From: Sarah Featherstone [REDACTED]
Sent: 25 June 2019 12:04
To: Anita Gardner
Subject: Re: CM/28/19/DOC and CM/27/19/DOC - Climping Mill, Climping Street

Detail D3 Patio Doors

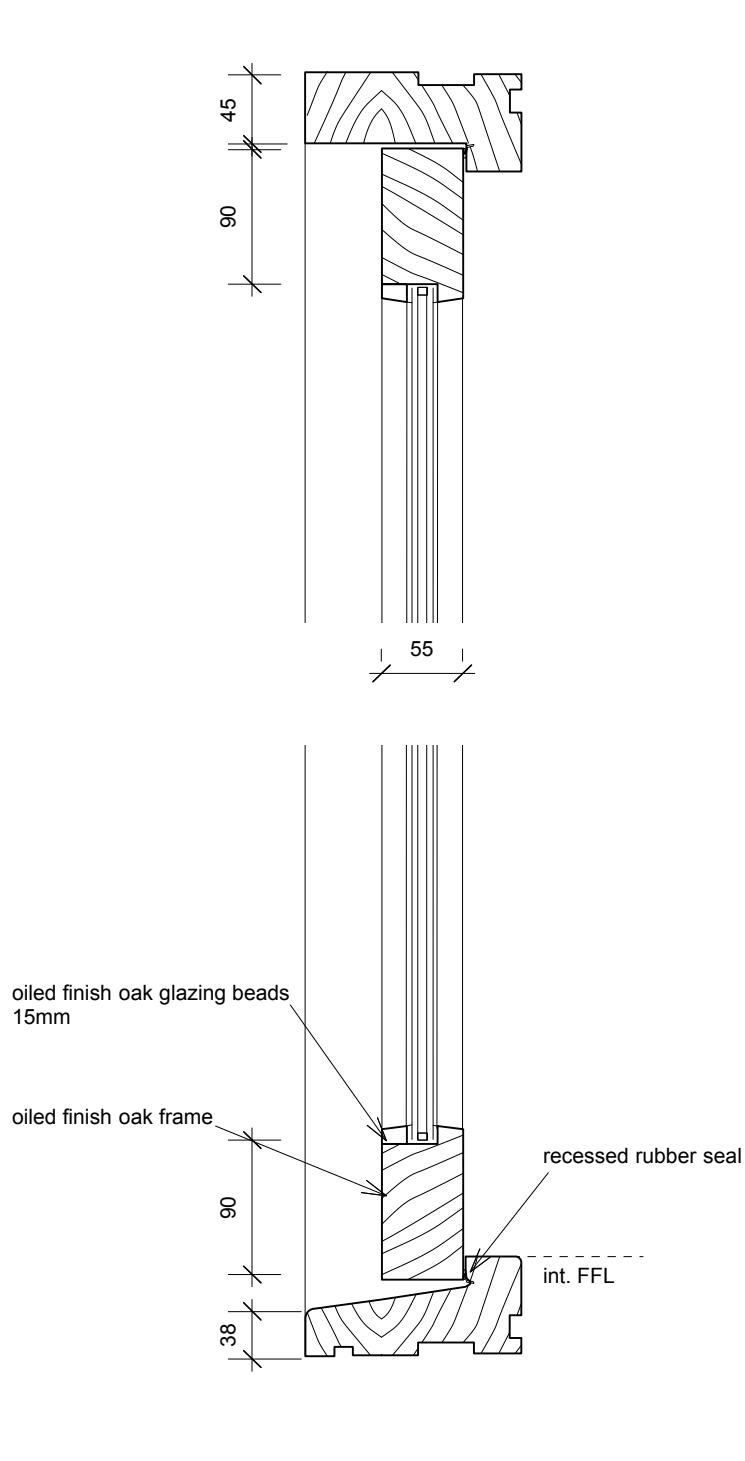
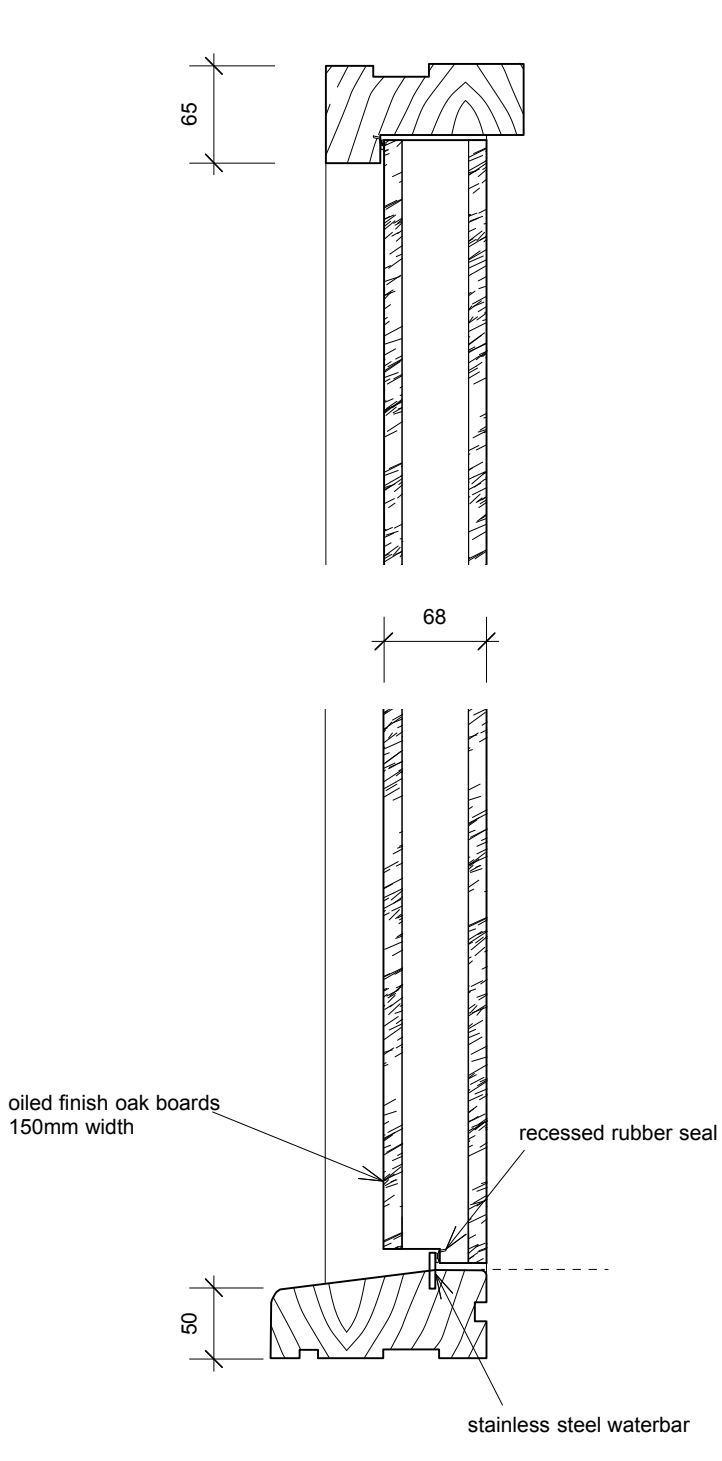
- it is not clear if the glazing is slimlight or standard thickness. The approved application refers to 14 mm slimline double glazing. Do the drawings provided as part of the DOC correspond with that approval?
- With regard to application CM/28/19/DOC please also confirm whether the details of colour provided, will this be used on the windows as well?

- Yes all windows are 14mm slimline as indicated on drawing 09 001 and in accordance with the approved application. The new glazed patio doors WG.01 & WG.04 were not referred to as having 14mm slimline dgu in the approved application and we show these to have 24mm standard DGU's as we think it will be difficult get 14mm slimline for these large glass sizes. If you think this may be problematic please let us know and we will investigate further.
- The finish of the external windows and doors are indicated as oiled oak on the DOC drawings and we did not envisage them being stained black, but are happy to change to black stain timber if preferred.
